CITY OF ALBUQUERQUE

August 17, 2023

Re: Farolito Senior Community
10501 Central Ave. NE
Traffic Circulation Layout
Engineer's/Architect's Stamp XX-XX-XX (L21-D074)

E X H I B I T ' A '

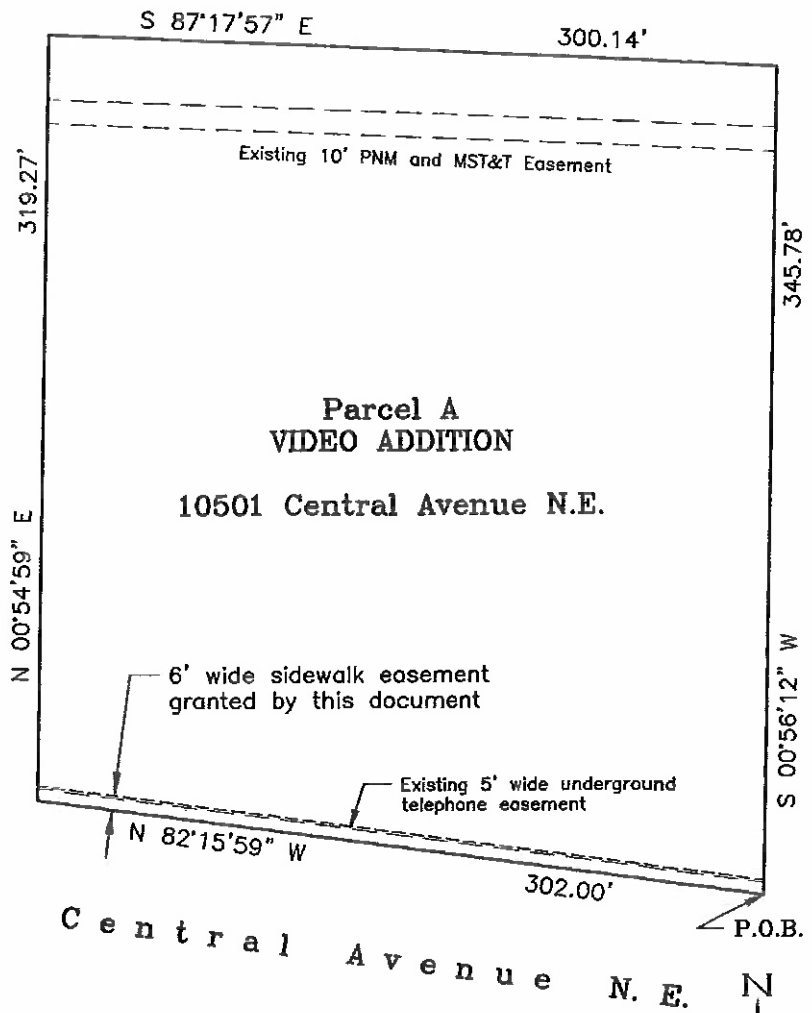
5. Due to propose 6' wide sidewalk, please clarify the status of the existing light poles.
6. Please provide sidewalk easement.
7. The Minimum parking space length is 18 ft. Please revise the site plan.

SHEET NO  
**TCL**

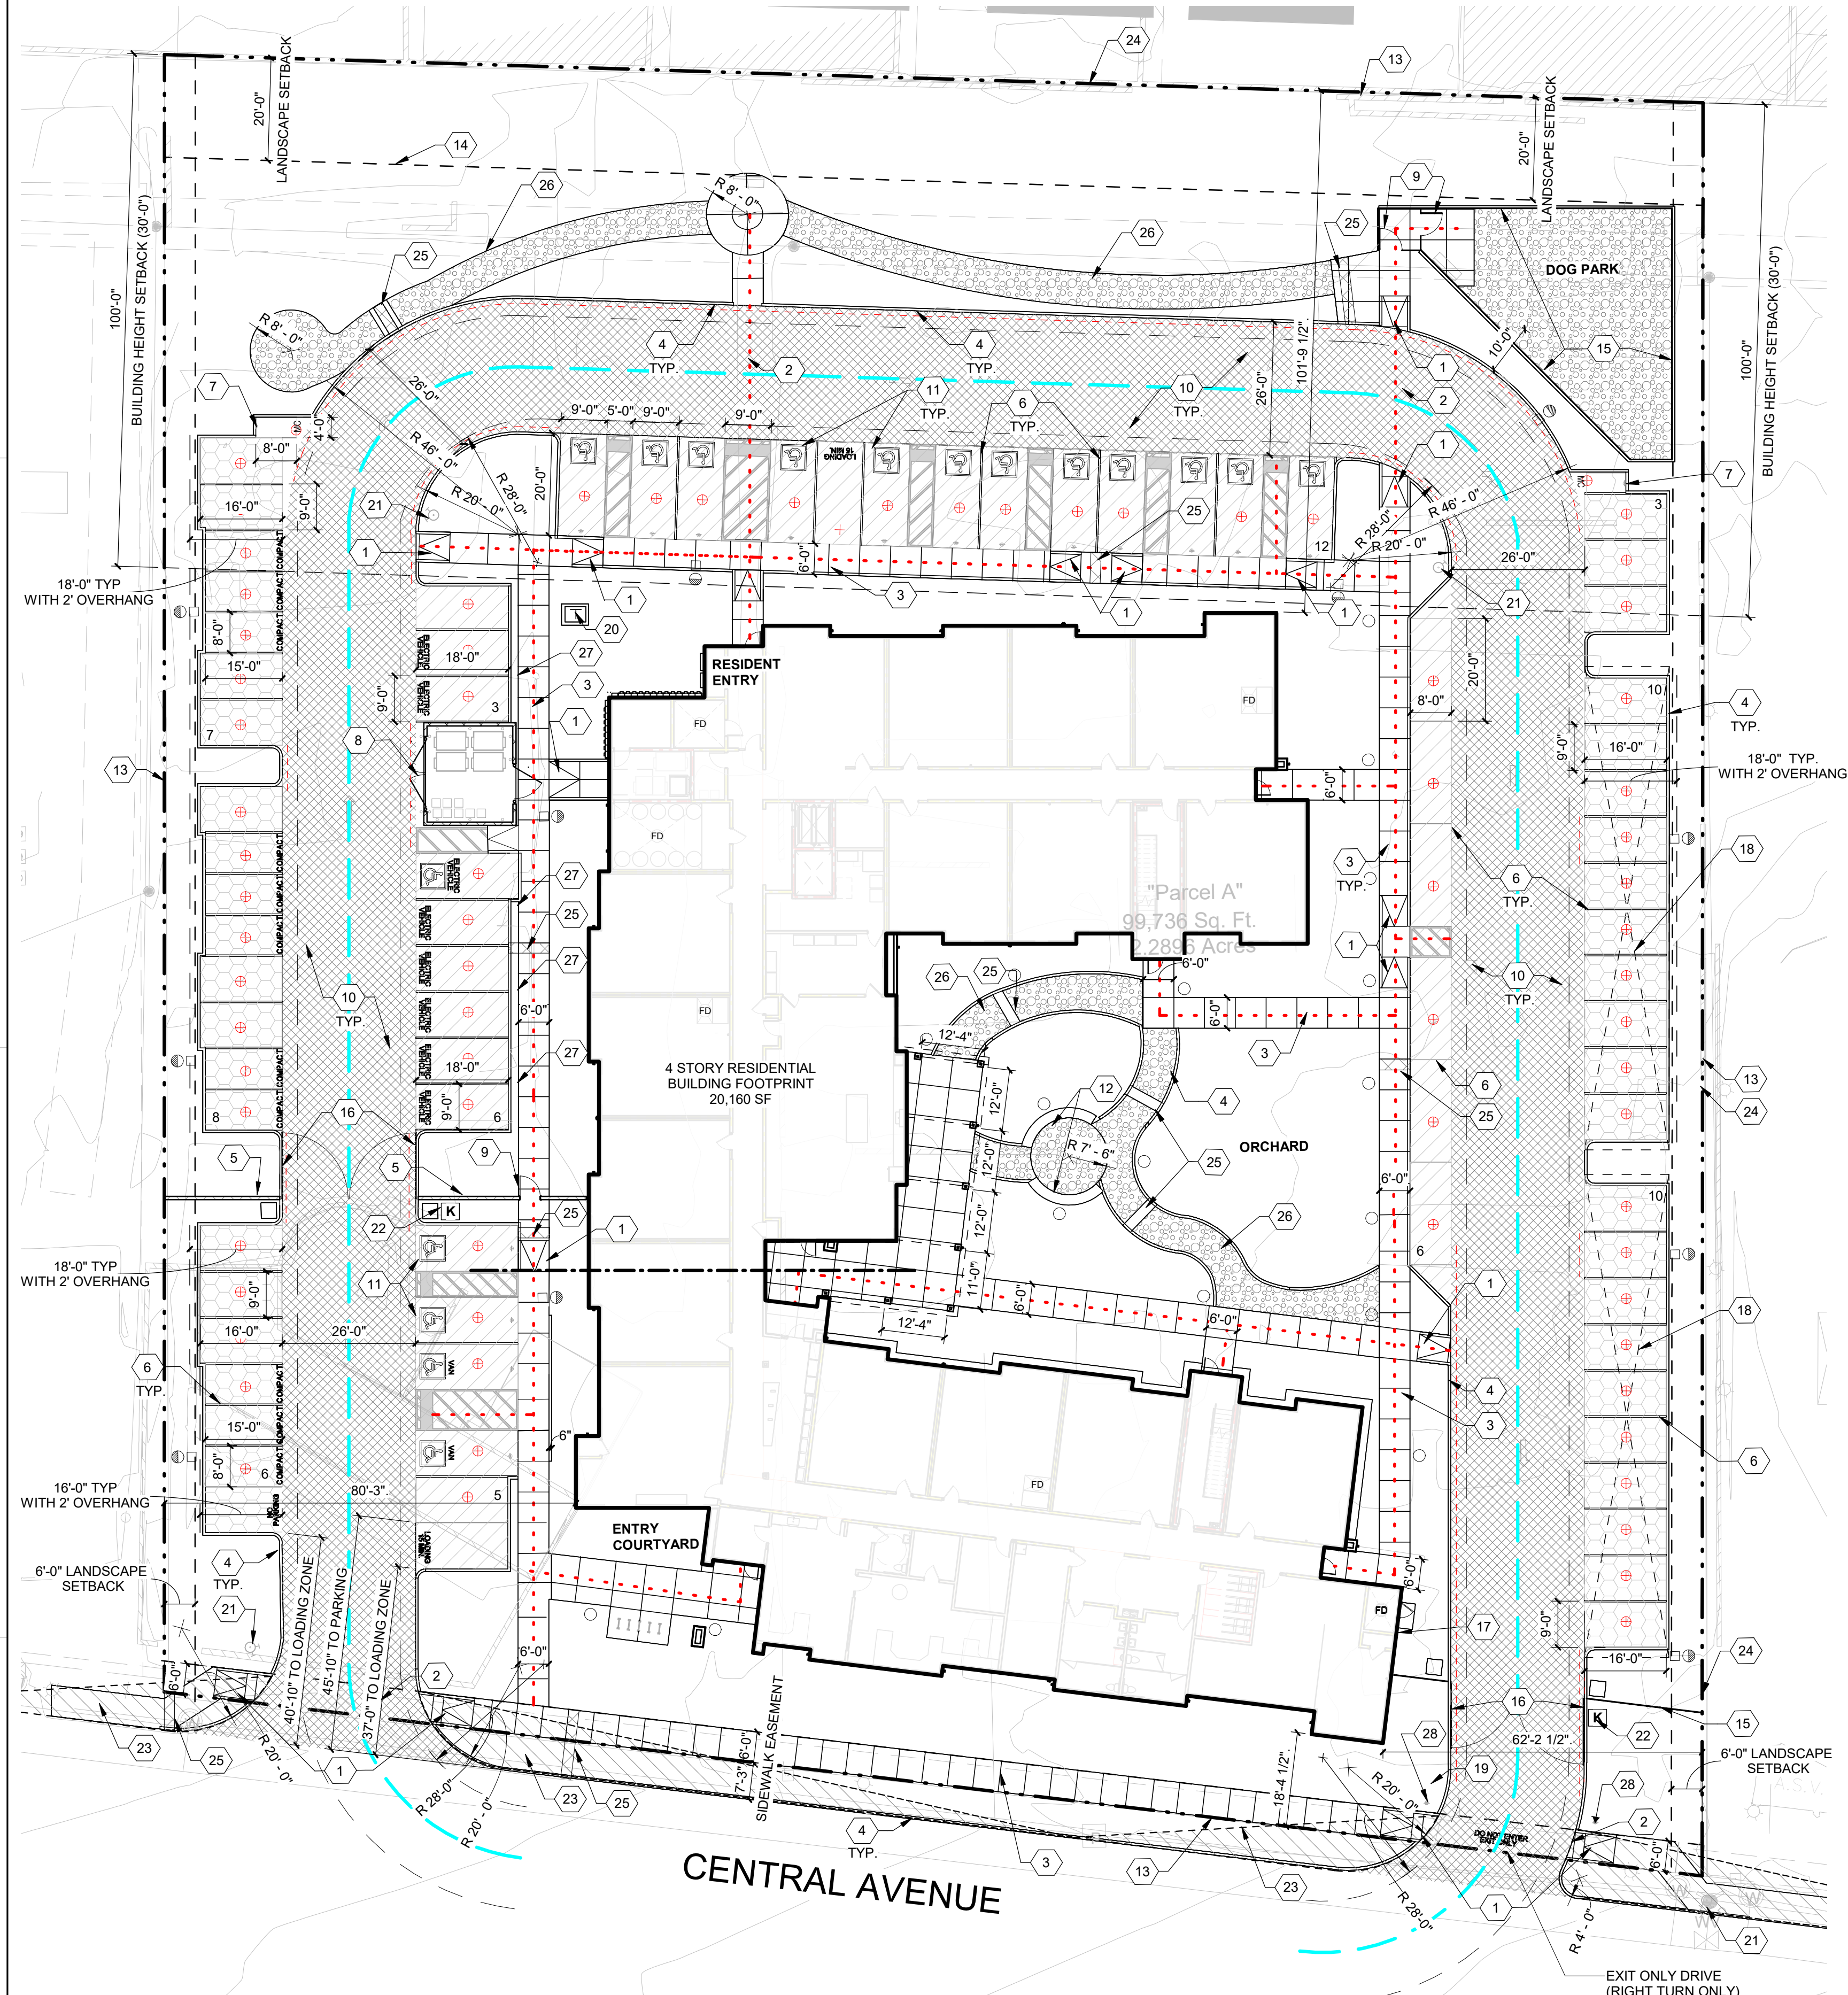
1. The traffic circulation layout must be stamped, signed, and dated by an engineer or architect licensed in the state of New Mexico.
2. Identify all existing access easements and rights of way width dimensions.

3. Identify the right of way width, medians, curb cuts, and street widths on Central Ave.
4. The Minimum throat length for both site accesses is 50 ft. please show this dimension on the site plan.

8. Details sheet is missing.
9. Please provide details for all the proposed ADA ramps.
10. The ADA accessible parking sign must have the required language per 66-7-352.4C NMSA 1978 **"Violators Are Subject to a Fine and/or Towing."** Please call out detail and location of signs.

11. The ADA access aisles shall have the words **"NO PARKING"** in capital letters, each of which shall be at least one foot high and at least two inches wide, placed at the rear of the parking space so as to be close to where an adjacent vehicle's rear tire would be placed. (66-1-4.1. B NMSA 1978)

12. Motorcycle parking spaces shall be designated by its own conspicuously posted upright sign, either free-standing or wall mounted per the zoning code.

13. The pavement marking "MC" should be shown in the opposite direction for motorcycles entering the parking space.
14. All bicycle racks shall be designed according to the following guidelines:

15. Bicycle racks shall be sturdy and anchored to a concrete pad.
16. A 1-foot clear zone around the bicycle parking stall shall be provided.
17. Bicycle parking spaces shall be at least 6 feet long and 2 feet wide.

18. Per the IDO, a 6 ft. wide ADA accessible pedestrian pathway is required from the public sidewalk to the building entrances. Please clearly show this pathway and provide details.

19. Per DPM, a 6 ft. wide ADA accessible pedestrian pathway is required from the ADA parking stall access aisles to the building entrances. Please clearly show this pathway and provide details.

20. ADA accessible pedestrian pathway should not be placed behind parking space or adjacent to a vehicular way. Vehicle and pedestrian/wheel chair conflicts should be avoided as much as possible.

21. Refuse vehicle maneuvering shall be contained on-site. The refuse vehicle shall not back into the public right of way.; provide a copy of refuse approval.

22. Provide a copy of Fire Marshal approval.
23. Show the Intersection clear site triangle for the west side site access.
24. Show the clear sight triangle and add the following note to the plan: "Landscaping and signage will not interfere with clear sight requirements. Therefore, signs, walls, trees, and shrubbery between 3 and 8 feet tall (as measured from the gutter pan) will not be acceptable in the clear sight triangle.

27. Please add a note on the plan stating "All improvements located in the Right of Way must be included on the work order."
28. Traffic Studies: See the Traffic Impact Study (TIS) thresholds. In general, a minimum combination of 100 vehicles entering and exiting in the peak hour warrants a Traffic Impact Study. Visit with Traffic Engineer for determination, and fill out a TIS Form that states whether one is warranted. In some cases, a trip generation may be requested for determination (**Contact Matt Grush: mgrush@cabq.gov**).

**B2 BICYCLE RACK PLAN**  
1/2" = 1'-0"

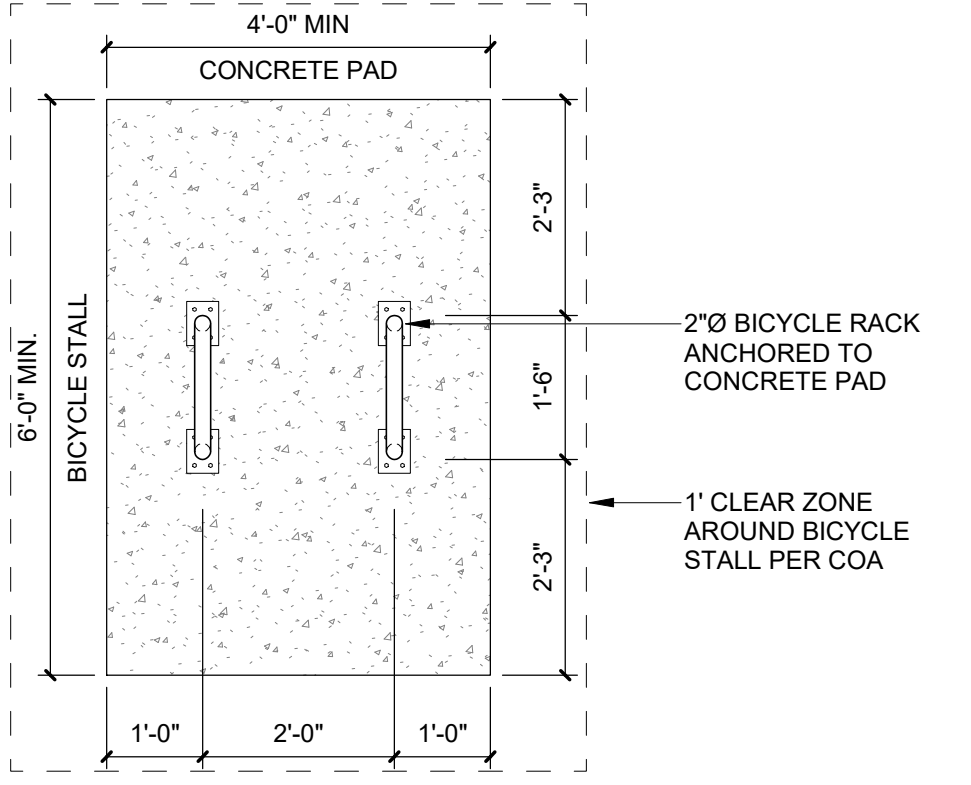
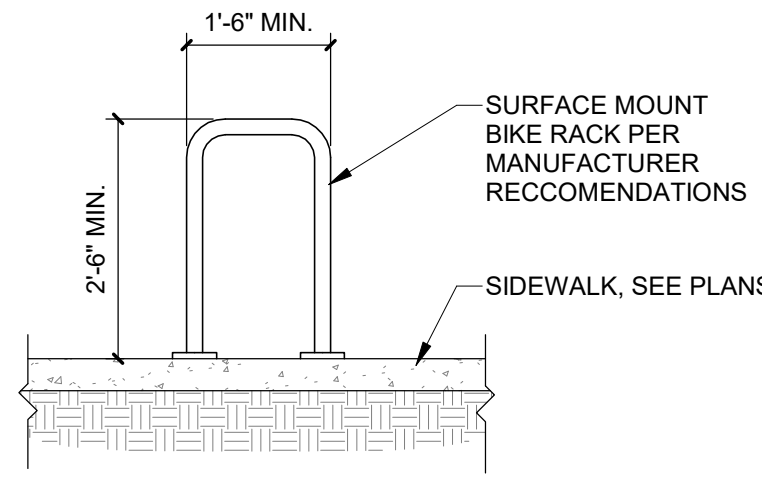
- a. The rack shall be a minimum 30 inches tall and 18 inches wide.

- b. The bicycle frame shall be supported horizontally at two or more places. Comb/toaster racks are not allowed.
 - c. The rack shall be designed to support the bicycle in an upright position. See the IDO for additional information.

- d. The rack allows varying bicycle frame sizes and styles to be attached.
 - e. The user is not required to lift the bicycle onto the bicycle rack.
 - f. Each bicycle parking space is accessible without moving another bicycle.
